From: Martyn White
Sent: 22 February 2019 09:24
To: Planning.Responses
Cc: Amber Willard
Subject: BR/324/18/L

BR/324/18/L

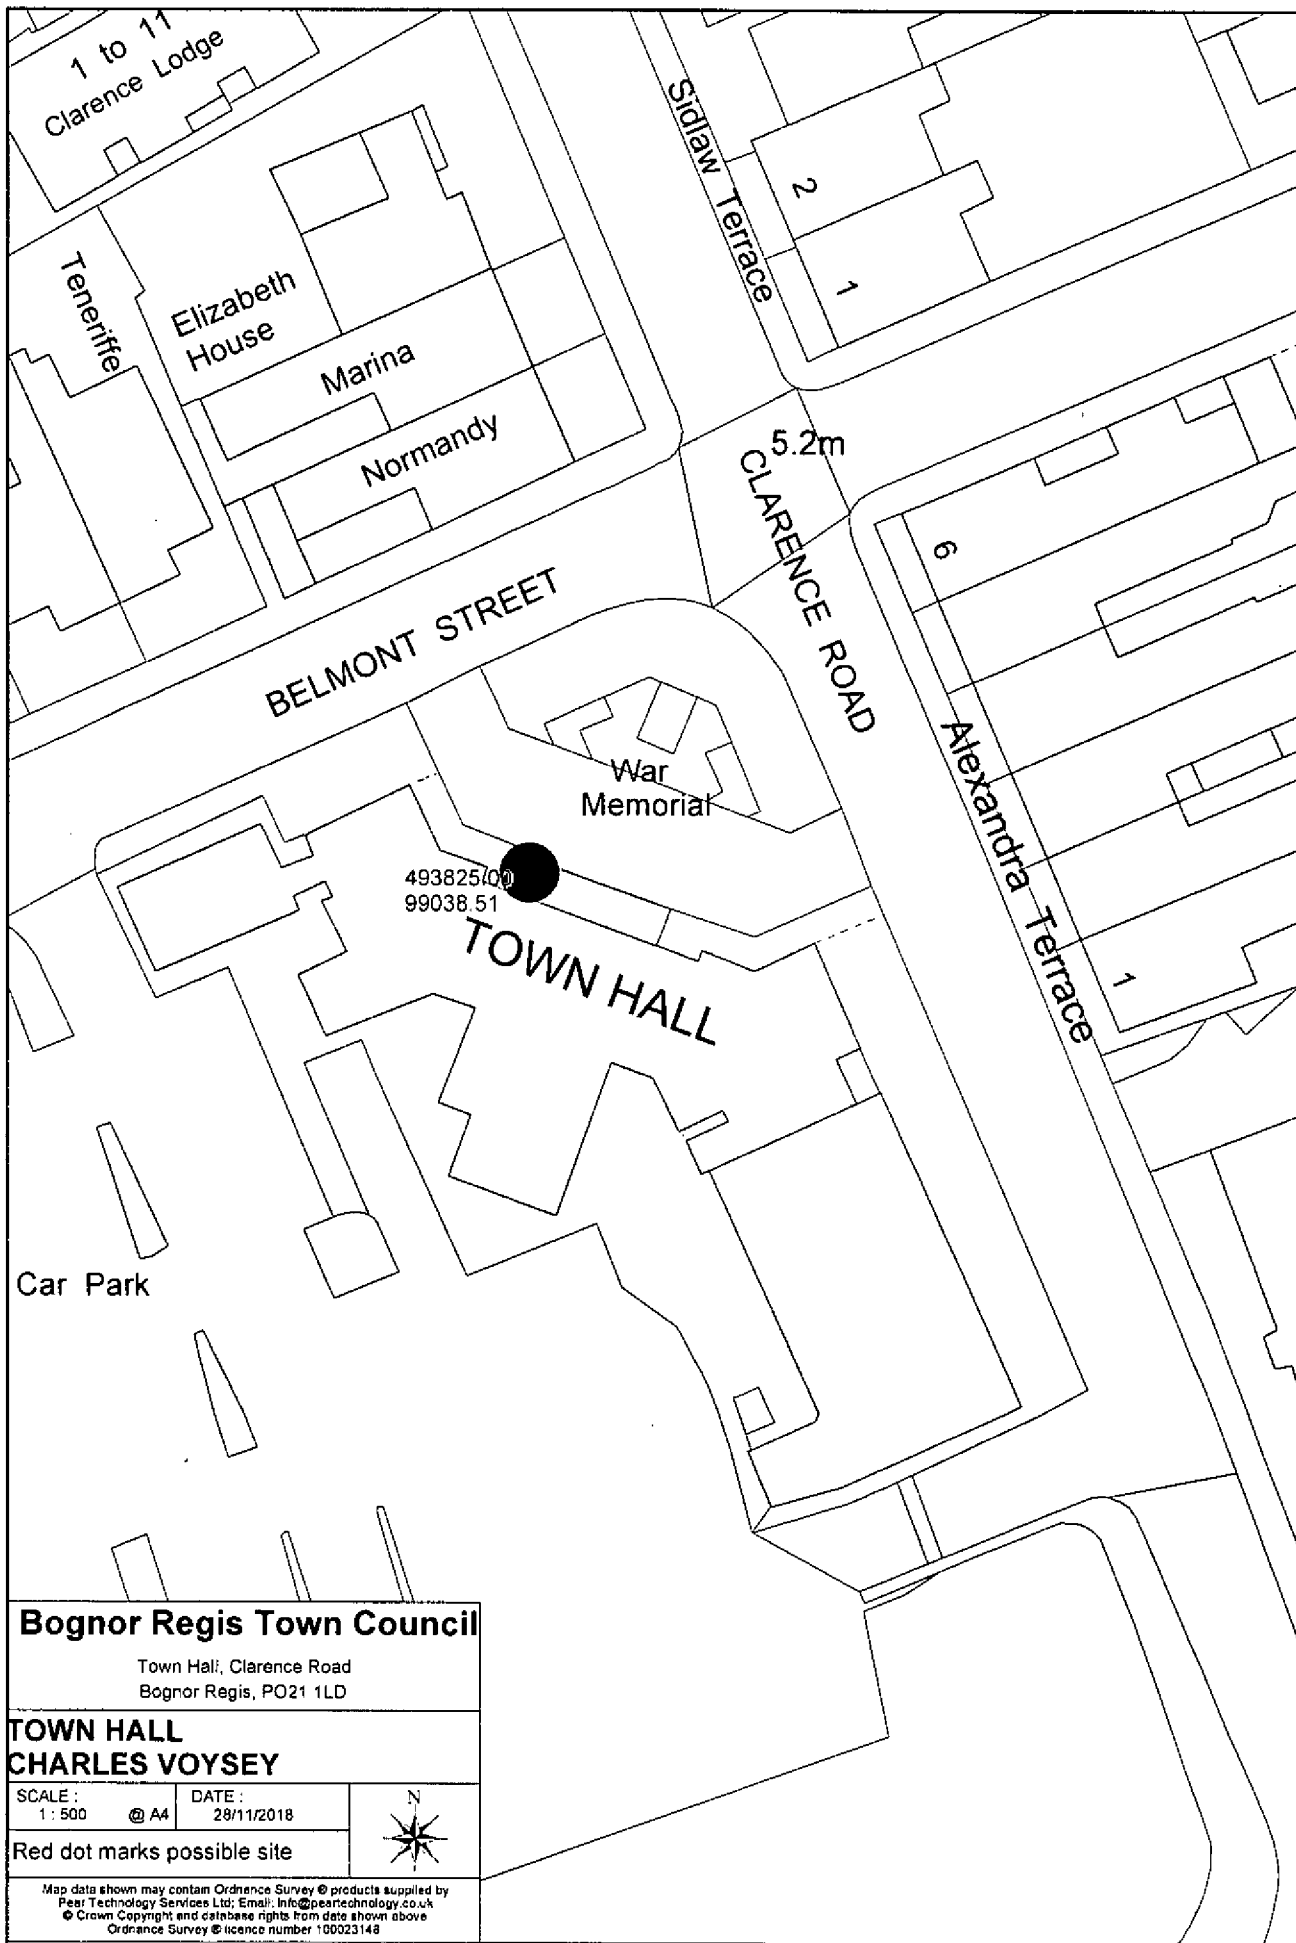
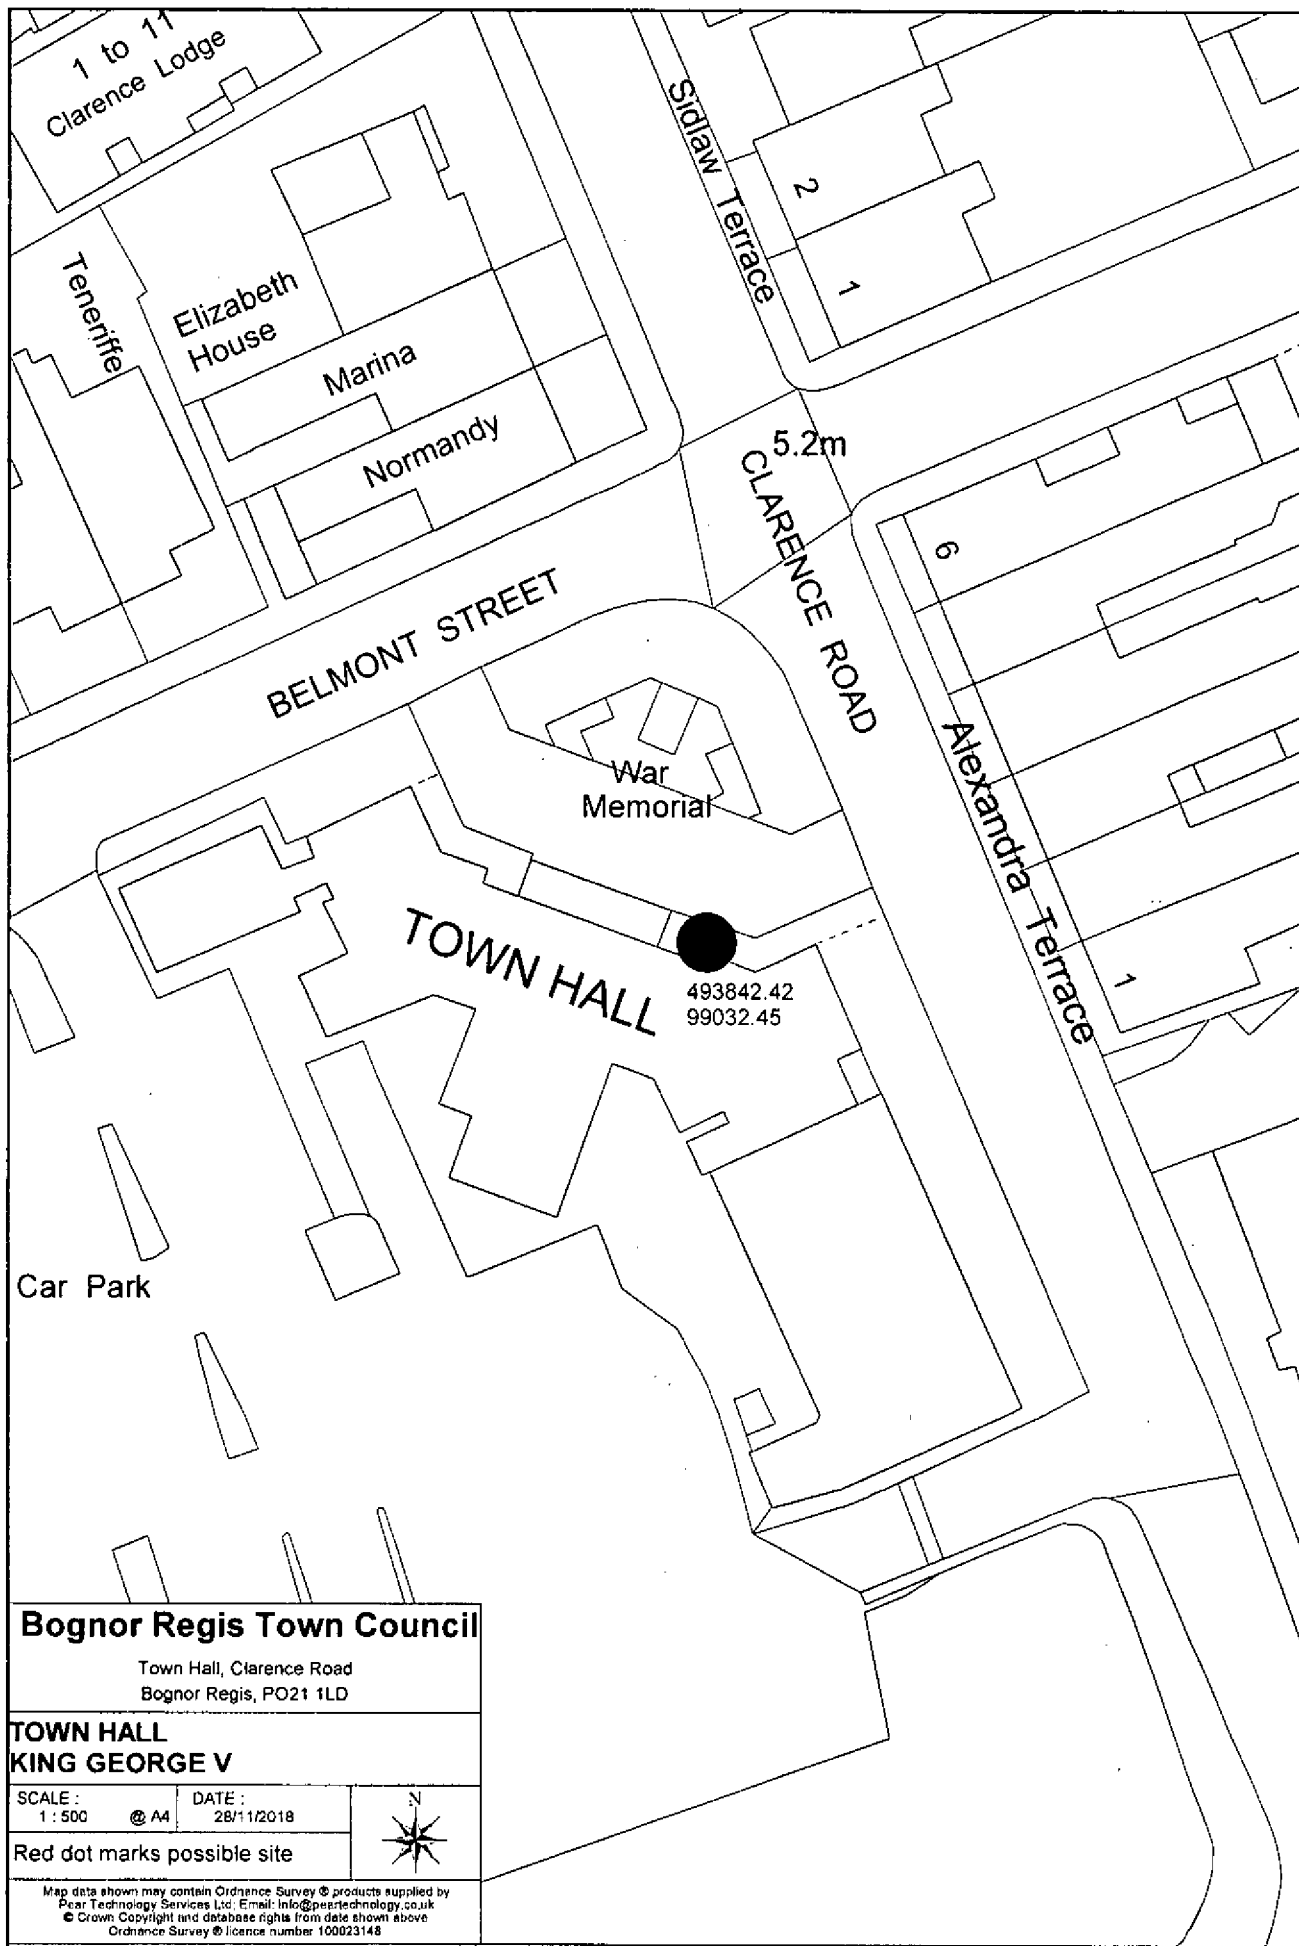
The proposal is to provide for two blue plaques to the front of the building on two of the empty piers. The plaques have a diameter of 15inch and commemorate the architect of the building and King George V bestowing the title of 'Regis' to the town. As both plaques are of relevance to the building, and are of an acceptable design and location, it is considered that the proposal is acceptable, and does not harm the significance of the building.
